From: Laura Gibbons
Sent: 22 May 2019 08:46
To: Planning.Responses
Cc: Stuart Corbey
Subject: RE: Planning Consultation on BN/26/19/DOC

Engineers Comments Regarding Condition 4- surface water drainage

APPLICATION BN/26/19/DOC

Registered: 02-MAY-19
Site Address: Flintstones Barnham Road Eastergate PO20 3RT
Description of Works: Approval of details reserved by condition imposed under ref EG/66/18/HH relating to Condition Nos 3 - foul water drainage and 4 - surface water drainage.

Client
Mr and Mrs Stroud
Drawing Title
Surface Water Drainage

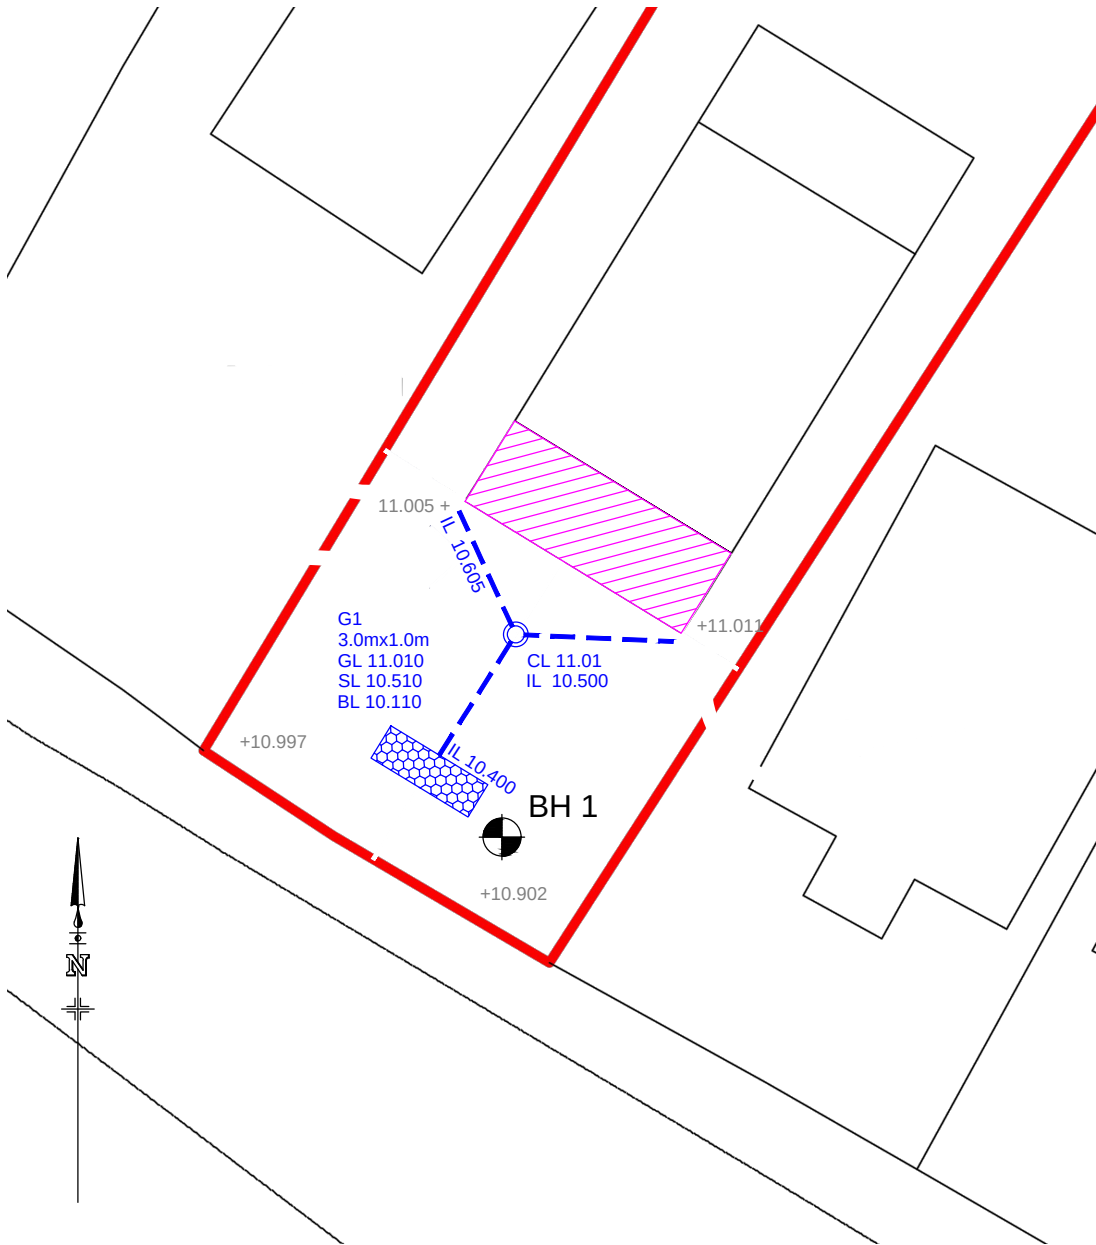
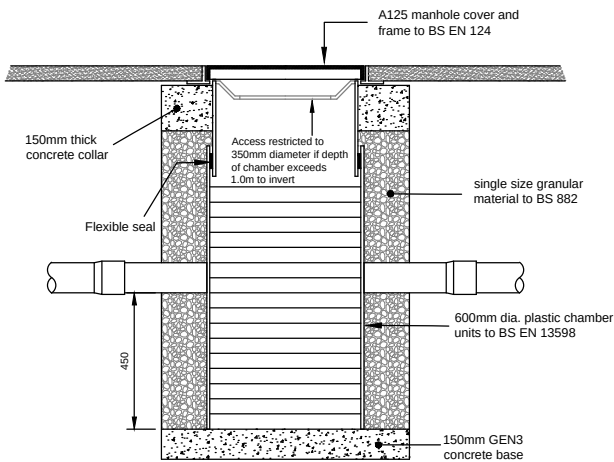
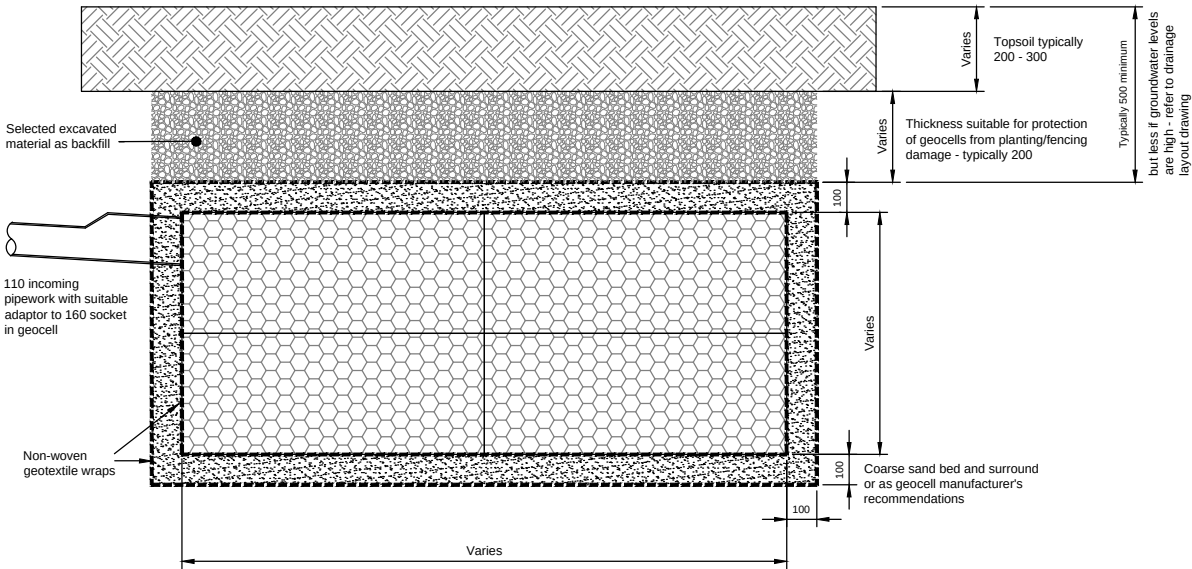
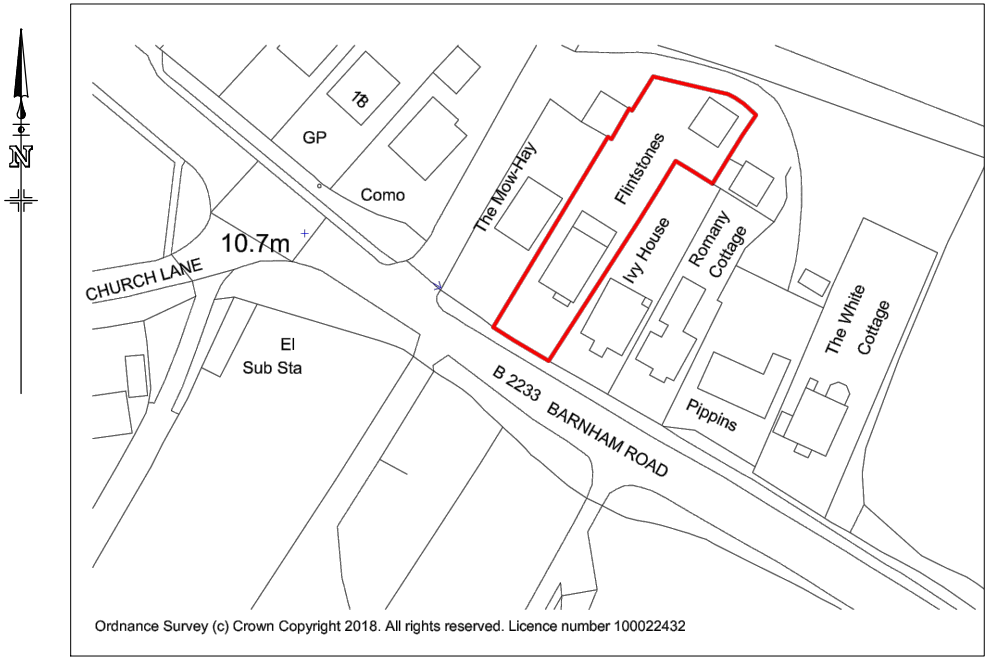
Please can more detail be submitted regarding infiltration testing completed. It is stated that an average is used because of the difference in results obtained at different depths. We would expect the worst case rate found at the proposed depth of the infiltrating structure to be used in design.

Please can the applicant also provide a factor of safety of 3 rather than 2.
